Add Title:  
O'Reilly Auto Parts Store  
Grading and Erosion Control Plan  
El Paso County, Colorado

# GEC Plan\_V1.pdf Markup Summary

O'REILLY AUTO PARTS STORE GRADING AND EROSION CONTROL PLAN EL PASO COUNTY, COLORADO

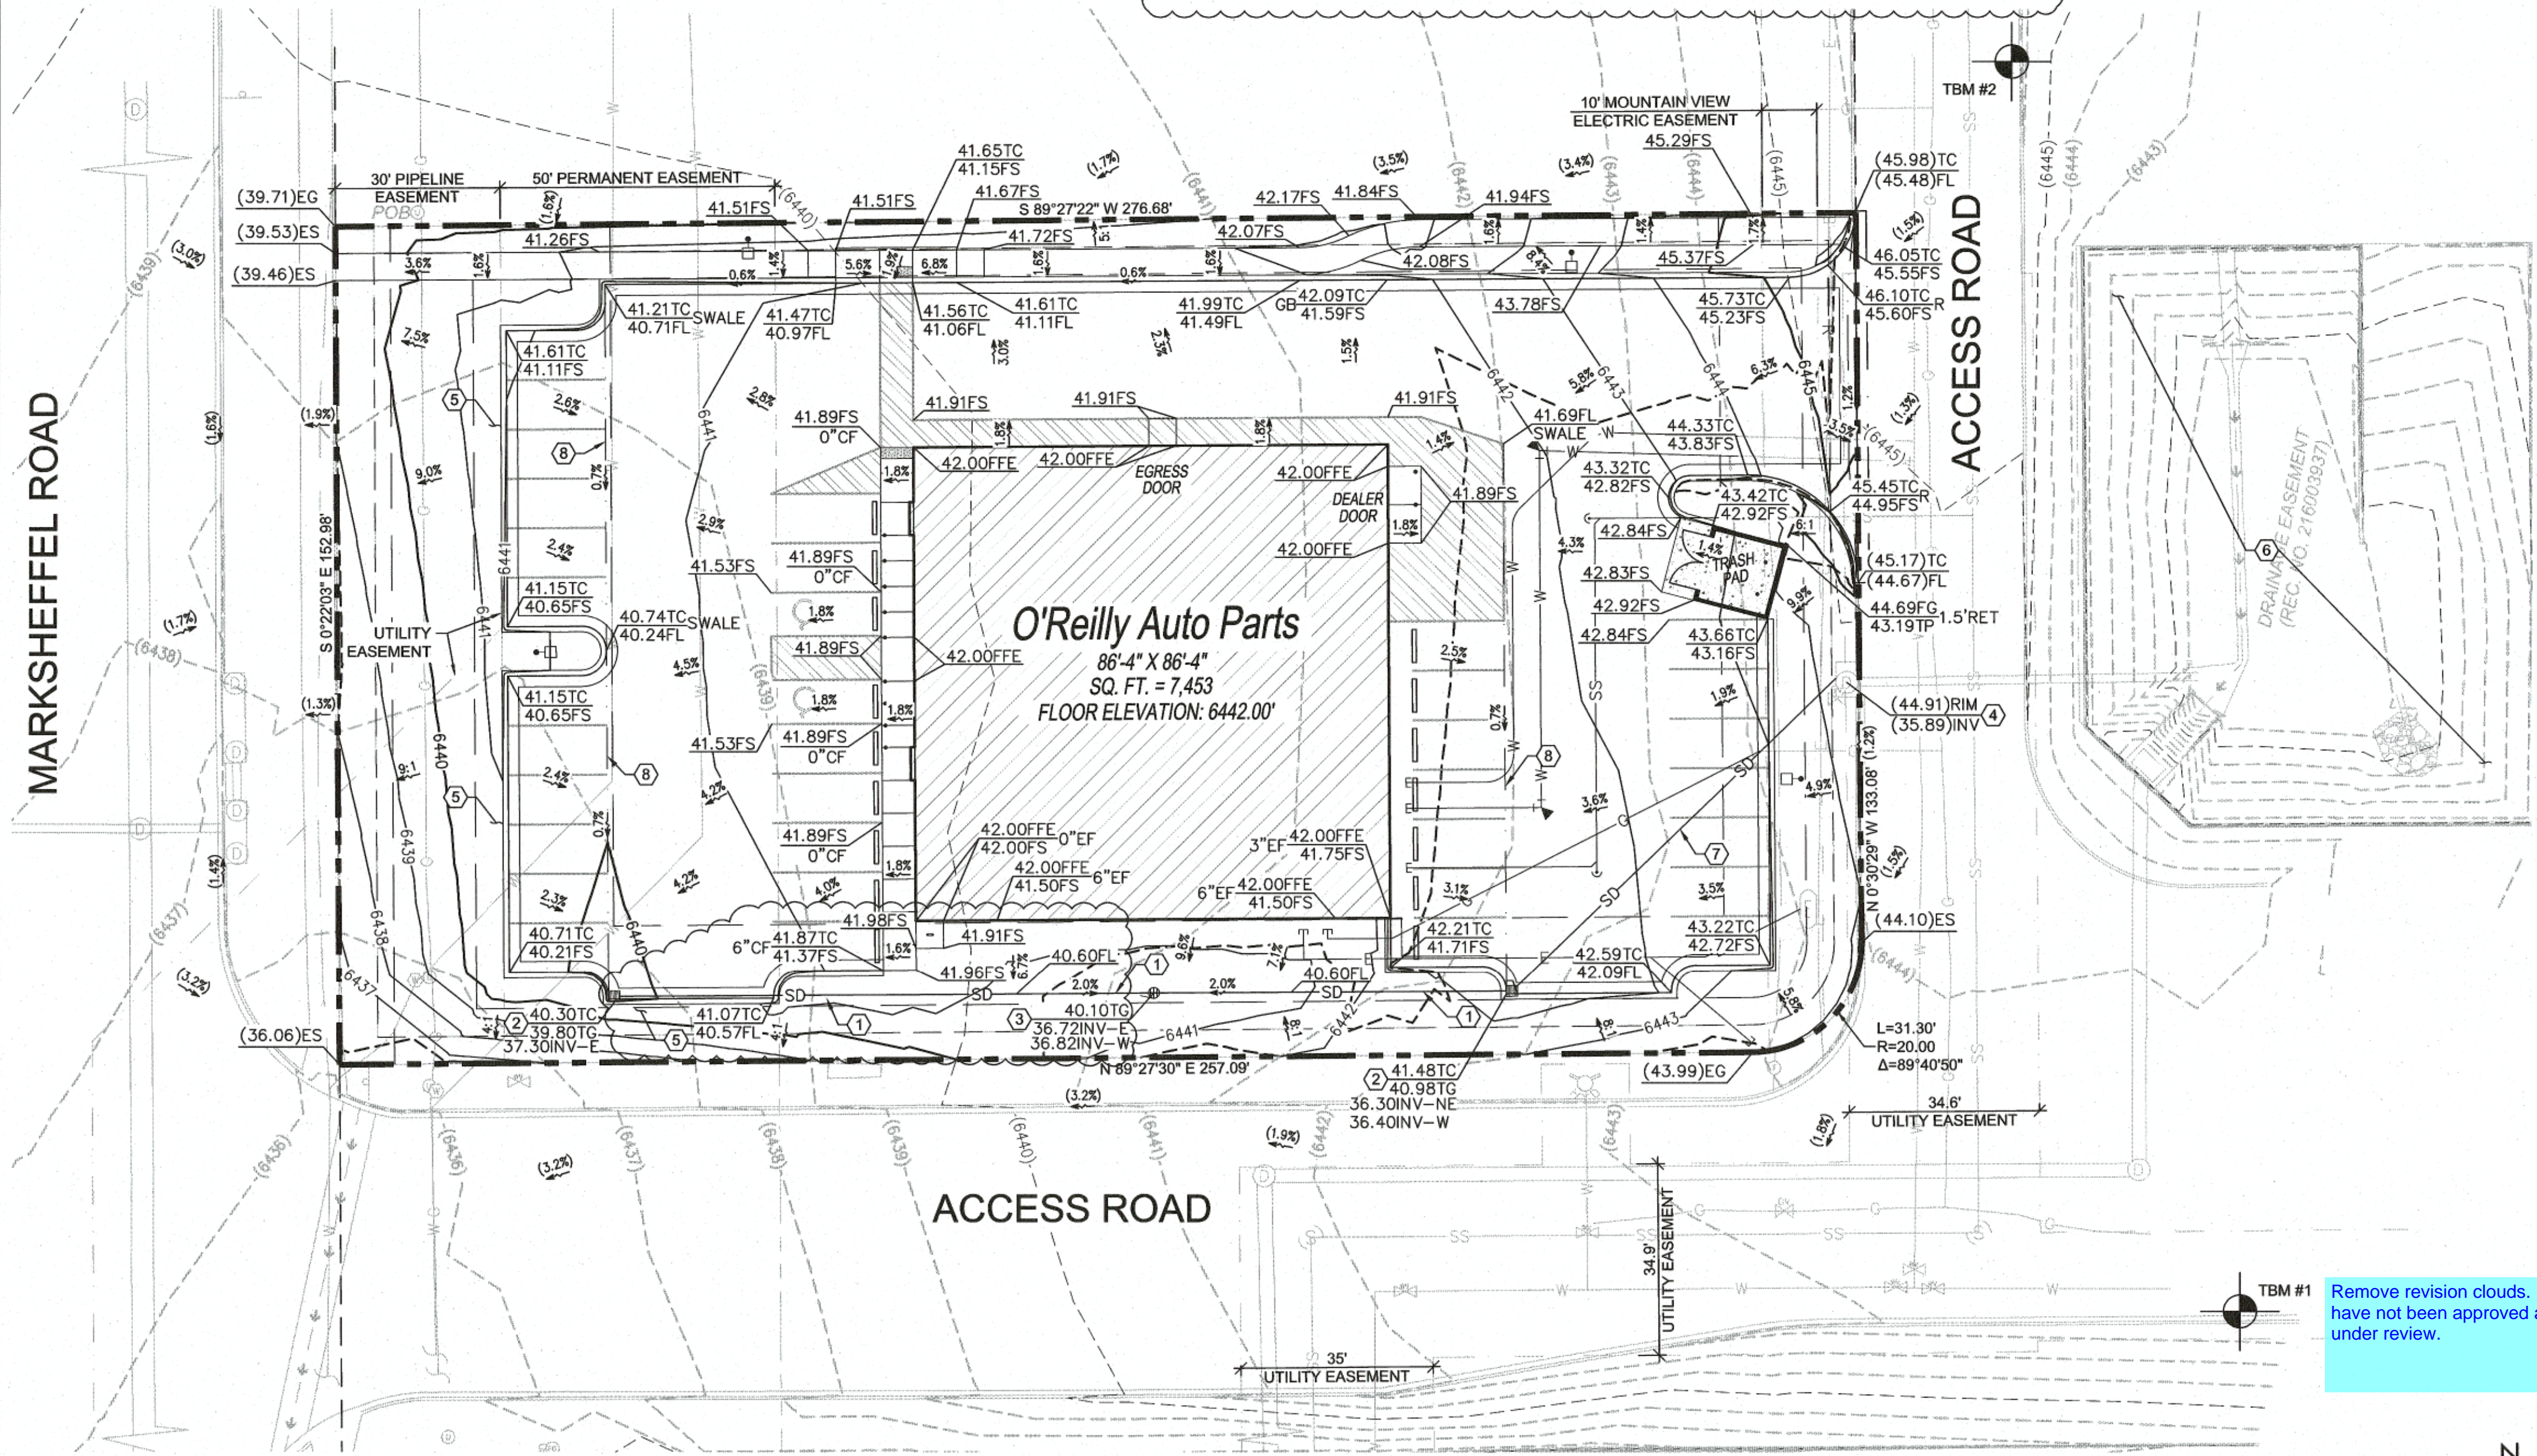
Add PCD File No. PPR202

Update signature block per the attached checklist.  
County signature block has a second paragraph.

PROJECT:
NEW O'REILLY AUTO PARTS STORE
N. MARKSHEFFEL ROAD
COLORADO SPRINGS, CO #11
SITE GRADING PLAN

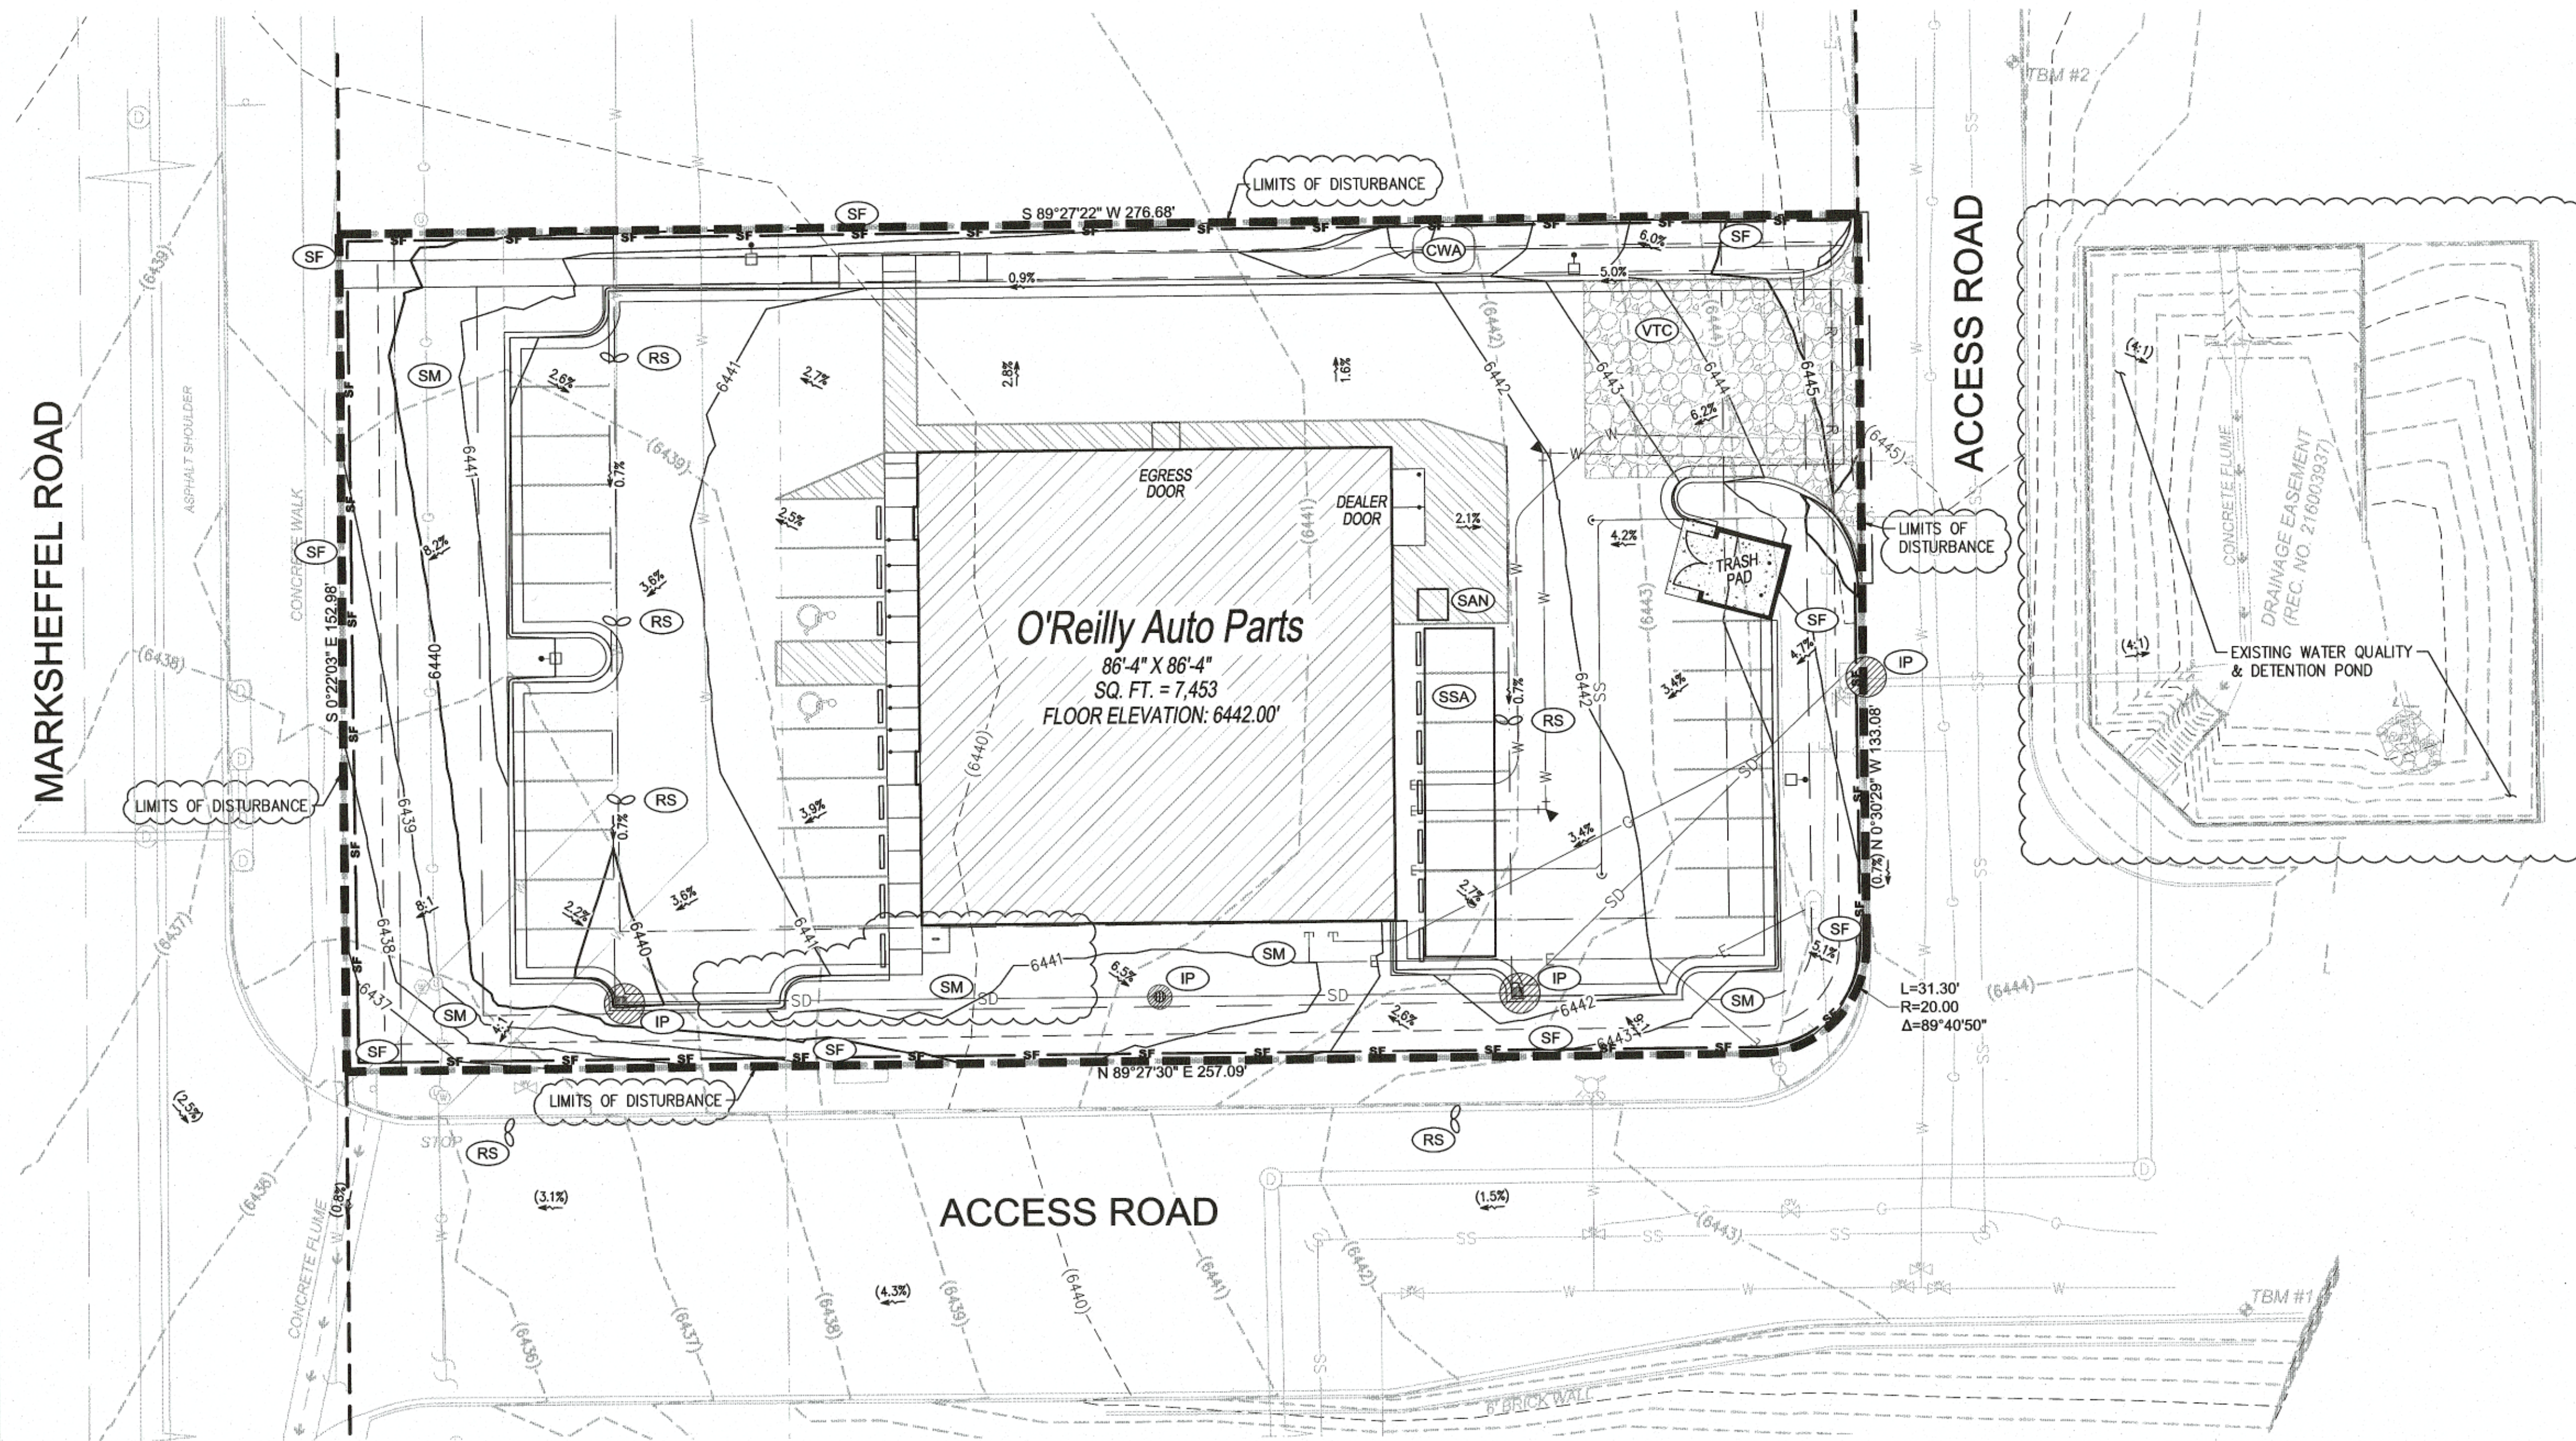
delineate and label the limits of construction and disturbance.

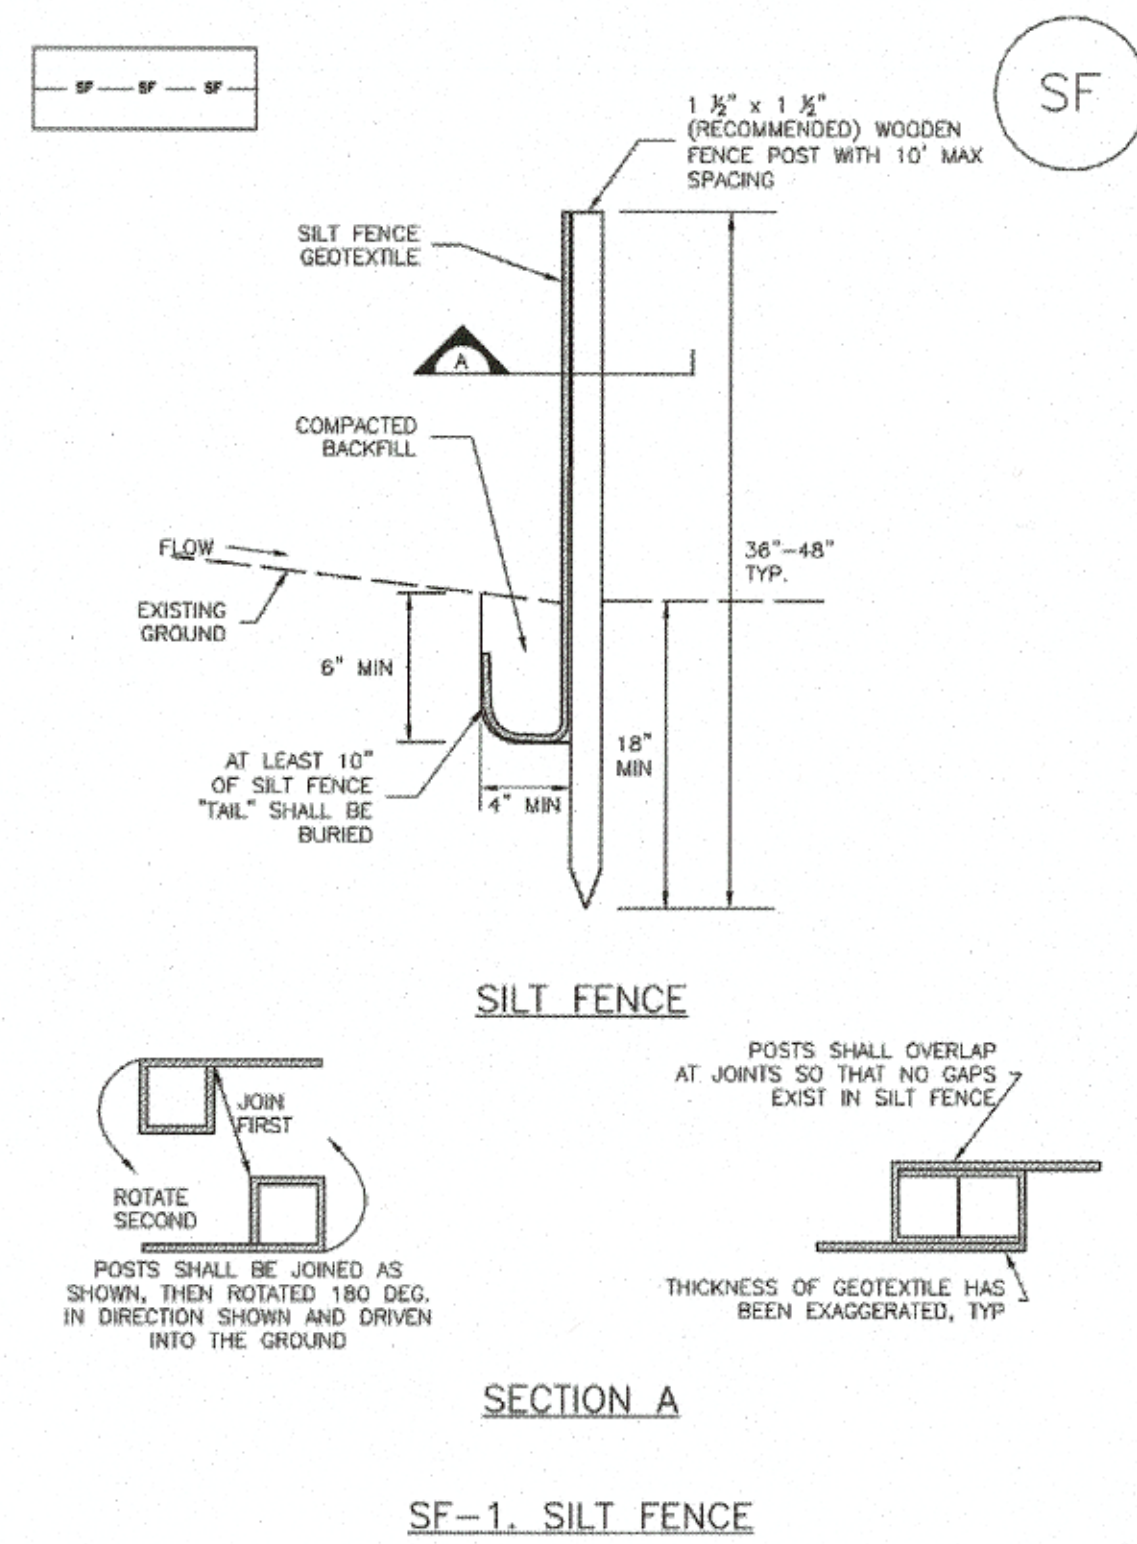
Replace with the latest notes from the GEC Checklist.

Include the temporary BMP details on the plan set.  
 Make sure details are sufficiently scaled to be legible when sheet is printed on 11x17
